Gunthwaite & Ingbirchworth Parish Council

16th March 2016

APPLICATION NO. 2016/0209
ERECTION OF 1no DETACHED DWELLING AND ERECTION OF
DETACHED GARAGE TO EXISTING DWELLING WITH REPOSITIONED
VEHICLE ACCESS ONTO PENISTONE ROAD, 2 WELLTHORNE LANE
INGBIRCHWORTH.

BLOCK PLAN

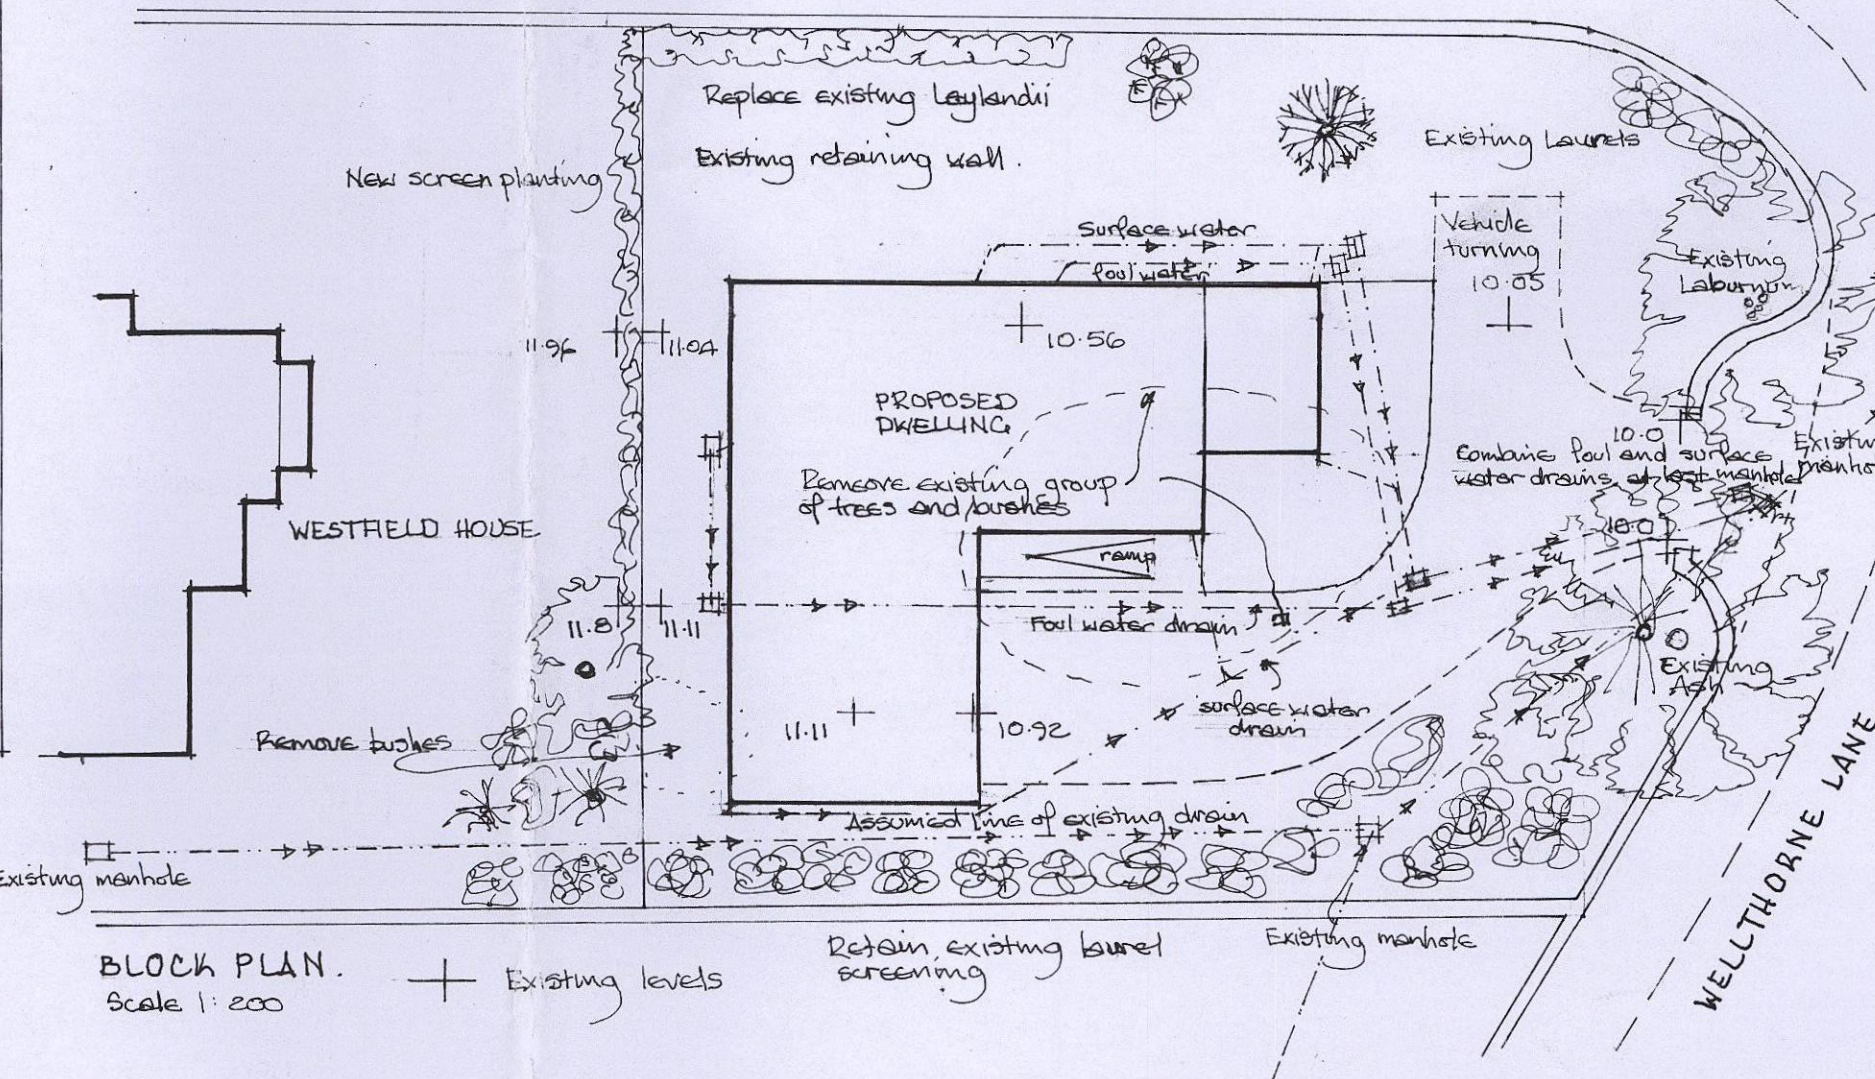
I would refer to the above planning application number which was discussed at the Parish Council meeting on Monday, 14th March. The Parish Council do not have any objections to the application but would like to make the comment that the hedge be left in situ. This hedge is a haven for wild birds etc. and should remain if at all possible.
